To: All Staff
From: Environmental Health
Date: December 29, 2025
Subject: BL-25-00020 Martin

TO: All Staff
FROM: Public Works Plan Review Team
DATE: December 23, 2025
SUBJECT: BL-25-00020 Martin

MARTIN BLA SITE PLAN

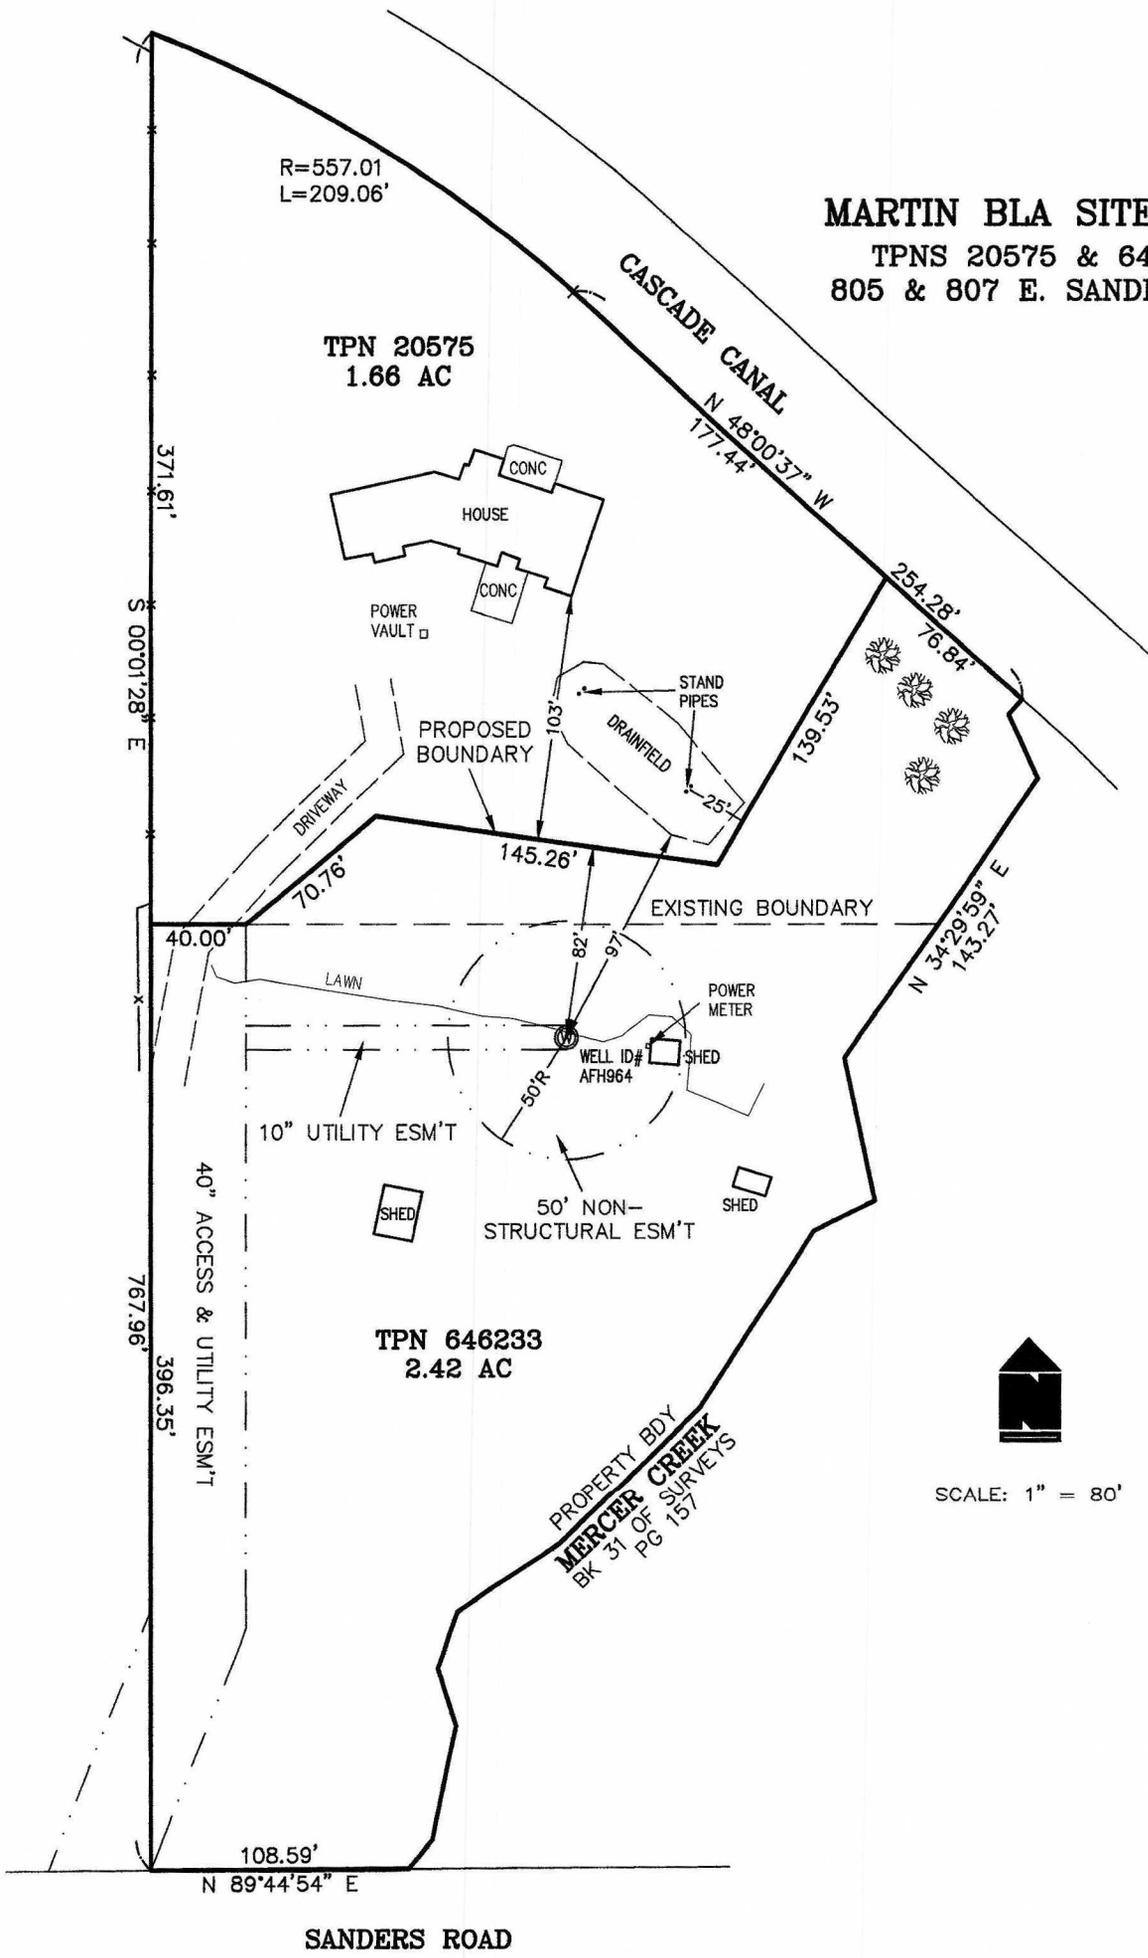
Drinking Water	<ul style="list-style-type: none">• No comment for boundary line adjustment.
Wastewater	<ul style="list-style-type: none">• Provide updated on site septic as-built verifying property lines are a minimum of 5 feet from the edge of the current mound system filter media and include reserve area location
